**CITY OF ALBUQUERQUE  
Planning Department  
November 14, 2007  
DRB Comments**

**PROJECT # 1006935**

**APPLICATION # 07-70372**

**RE: Lot 52-A, Cavalier Addition/minor plat**

**PLAT OF
 LOTS 52-A-1 AND 52-A-2
 CAVALIER ADDITION**

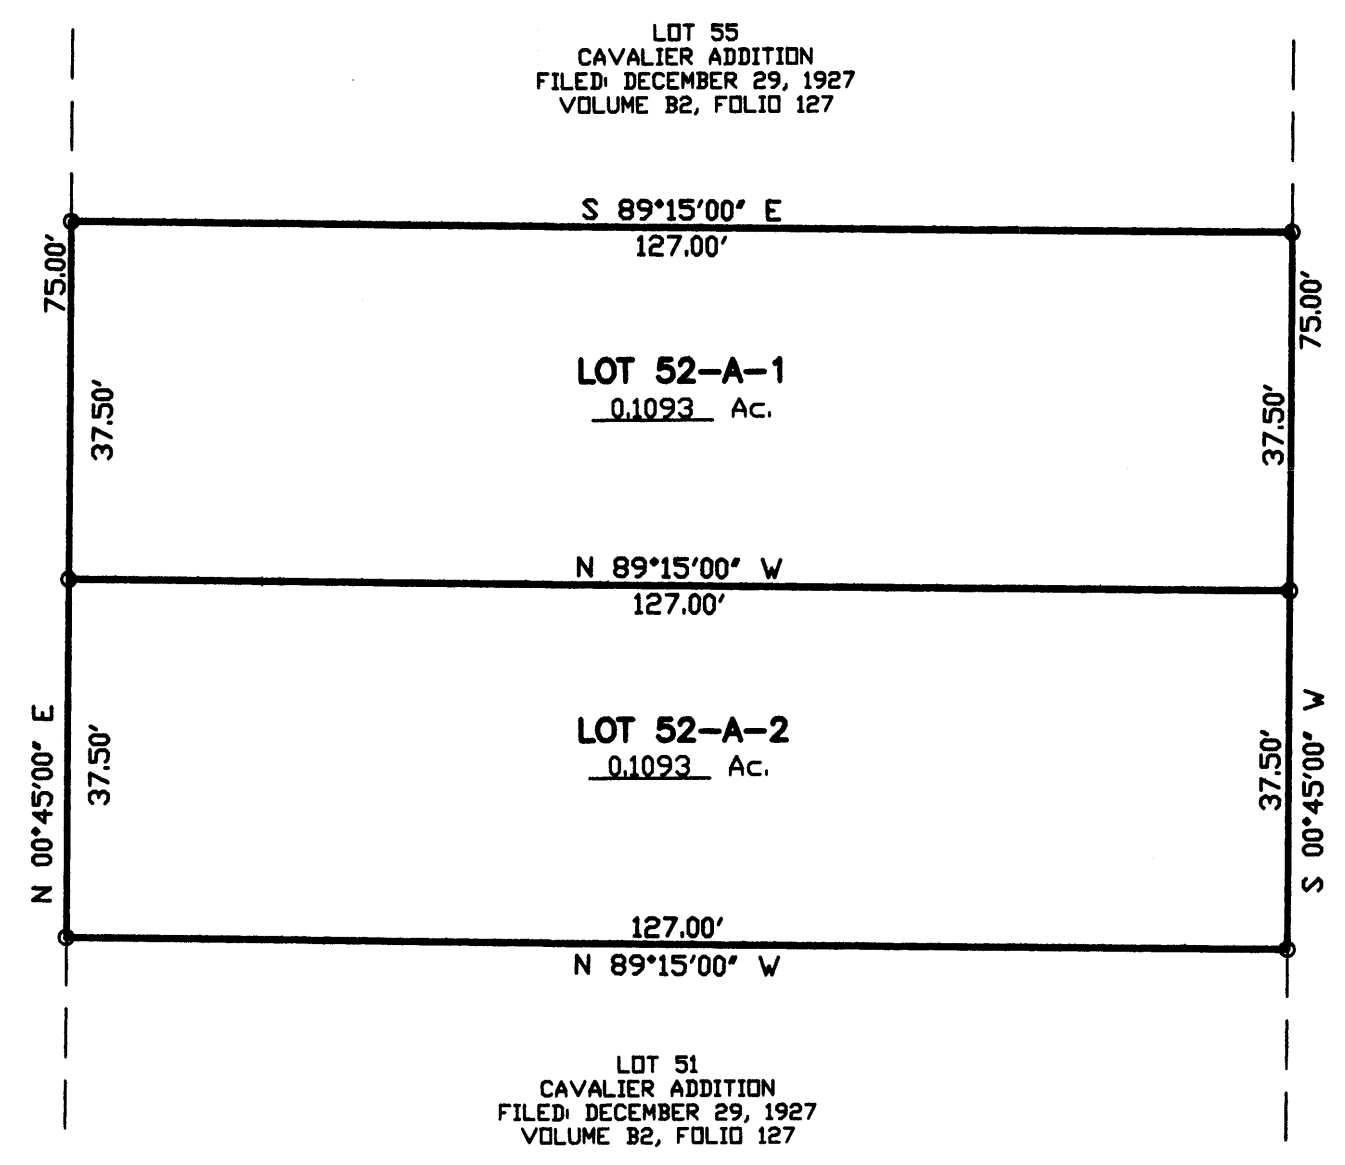
R-3 zoning requires a minimum lot width & depth of 150 feet. (Section 14-16-2-12(D)(1) of the Zoning Code. This lot is already non-conforming. To subdivide it would make the 2 lots even more non-conforming.
